DELEGATED LISTED BUILDING DECISION

Address LAND FORMING PART OF 2 ARLINGTON DRIVE RUISLIP

Development: Erection of two new semi-detached two-storey houses (4 and 6 Arlington Drive) with two new vehicular access and crossovers, part demolition of front boundary wall and site landscaping (Application for Listed Building Consent).

LBH Ref Nos: **71084/APP/2017/3604**

dwg. no. 12

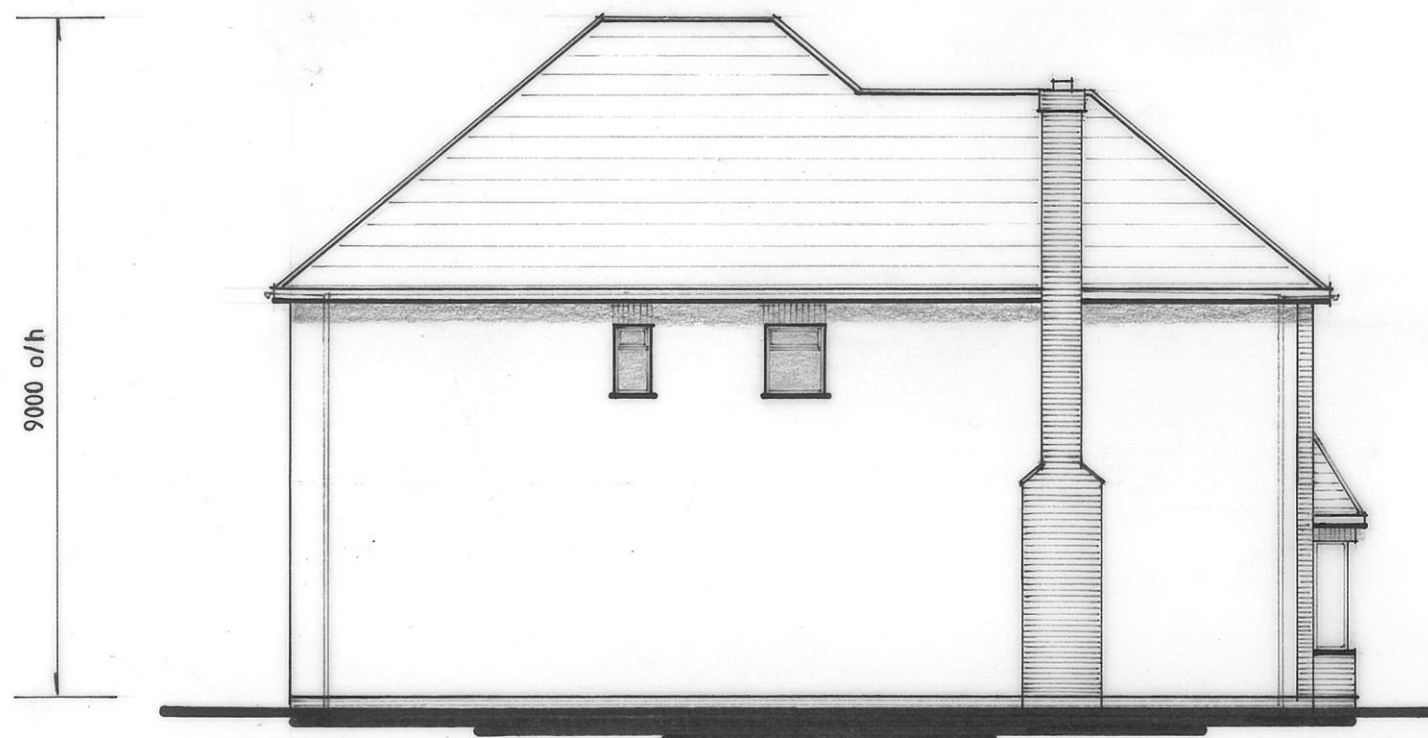
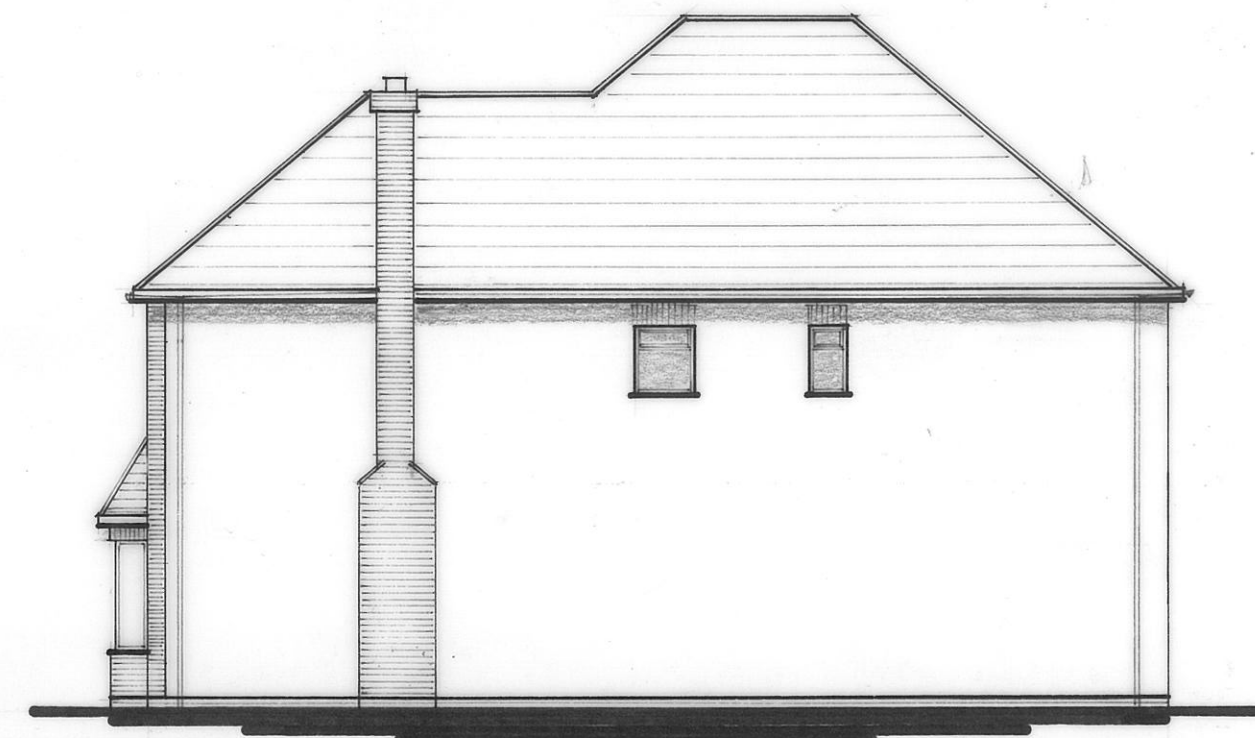
From the plans provided which do not show a scale, it is difficult to estimate the exact height of the new houses, but both appear to be very wide, occupying most of their plots and from the elevations high, making each wider and possibly higher than the listed building. The new houses will be squashed onto narrow plots and have an inadequate space for parking cars off the road. Parking on the street is a major problem in Arlington Drive. Provision of cycle sheds blocking the narrow pathways to the back of the houses will not solve this problem.

The proposed new houses are of a design that reflects something of the detailing and character of the existing 20th century houses that line the road. However, on the eastern side of the street these are detached, with gaps between each building. A semi- detached pair would, therefore, be conspicuous within the street scene.

Whilst the design of the proposed new houses does reflect something of the detailing and character of the existing 20th century houses that line the road, given that the majority of the houses on the street and surrounding area are detached, with gaps between each building, the proposed semi-detached pair of houses would be conspicuous within the street scene; due to the limited set in from the existing and proposed side boundaries, the proposed dwellings would not be in keeping with the character, appearance and design of the neighbouring detached properties in the immediate street scene and wider area.

dwg. no. 10

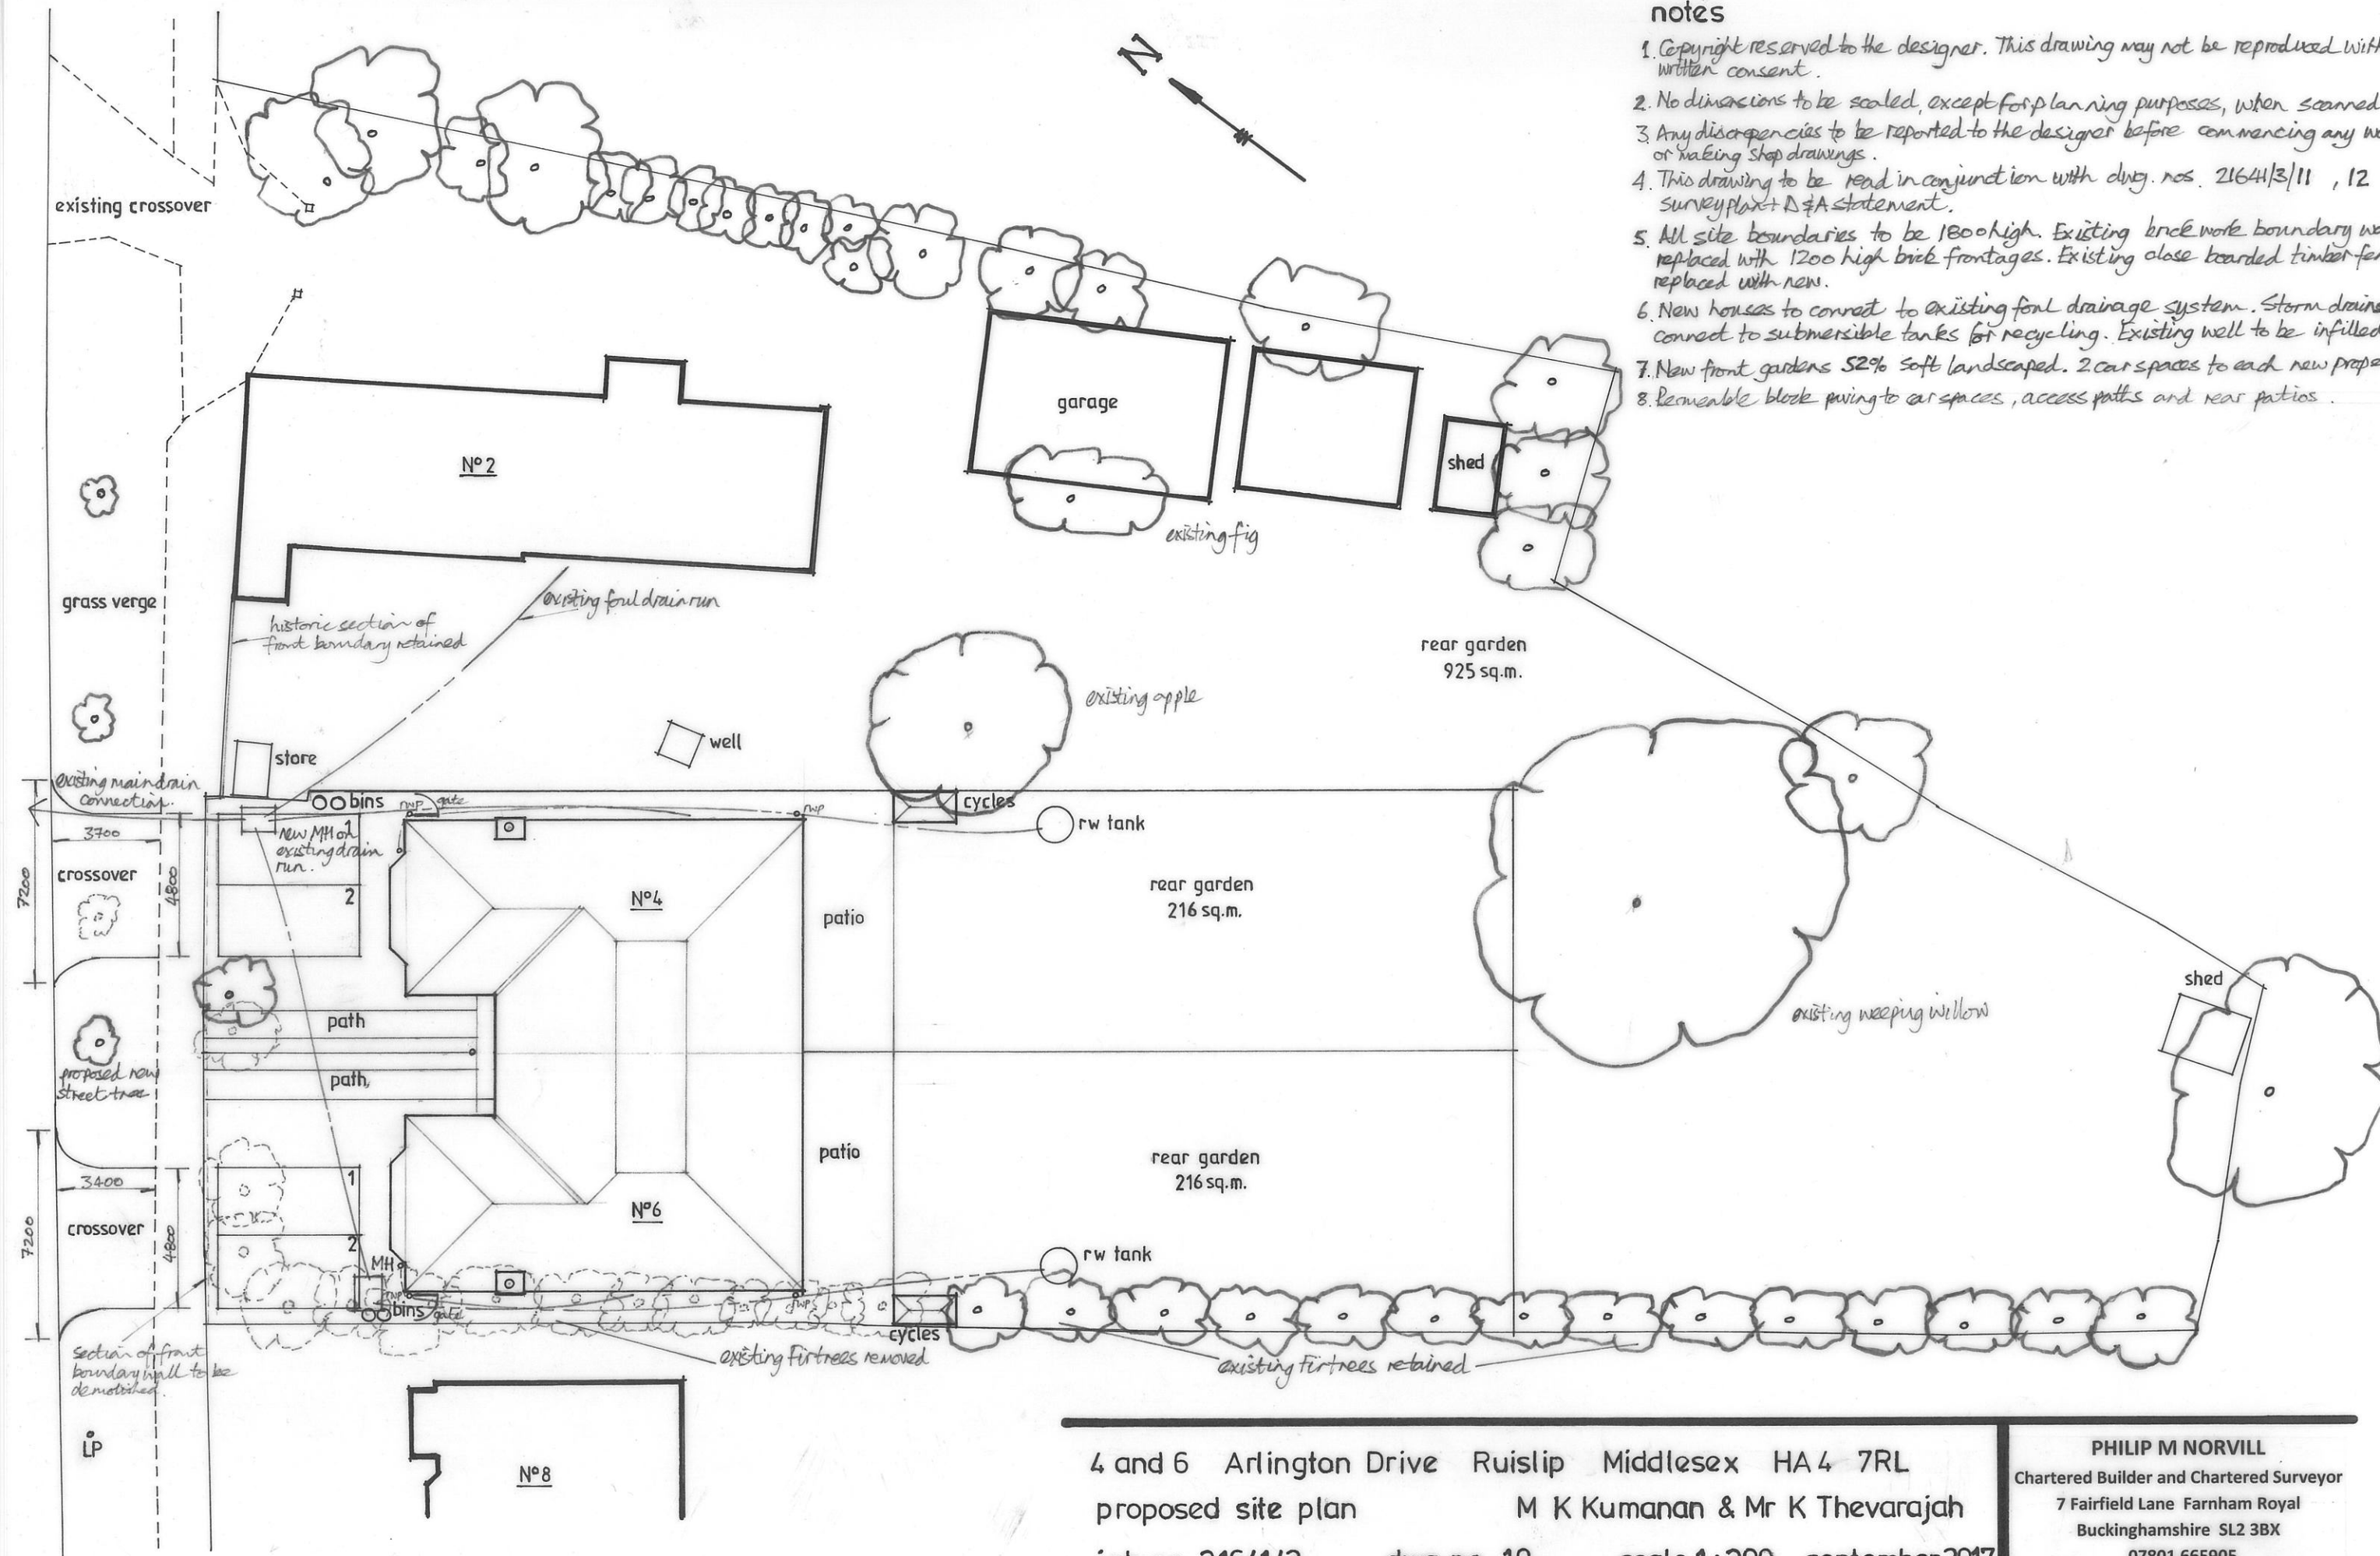
If the site were developed as proposed, the listed building would retain only a narrow plot with its principal rooms looking onto a wall/fence located just 8m away, and above this, the 2 storey flank of the proposed new houses.

The existing open garden aspect to the rear of the house would be lost, as would a number of the mature trees on the site boundary and within the garden.

The historic building would be left with a significantly smaller and awkwardly shaped plot, that would not reflect its rural character, its size or orientation. The historic boundary wall to the garden would also need to be demolished to create the open frontage and wide access points for the new houses and car parking.

The proposed development would result in part of the historic garden wall along the front boundary being demolished in order to create two new accesses to the site. In addition, an existing well on the site would be in-filled. The opening up of the wall and the loss of the well would result in the loss of historic features within the site and so would have a detrimental impact on the significance and setting of the Grade II Listed Building.
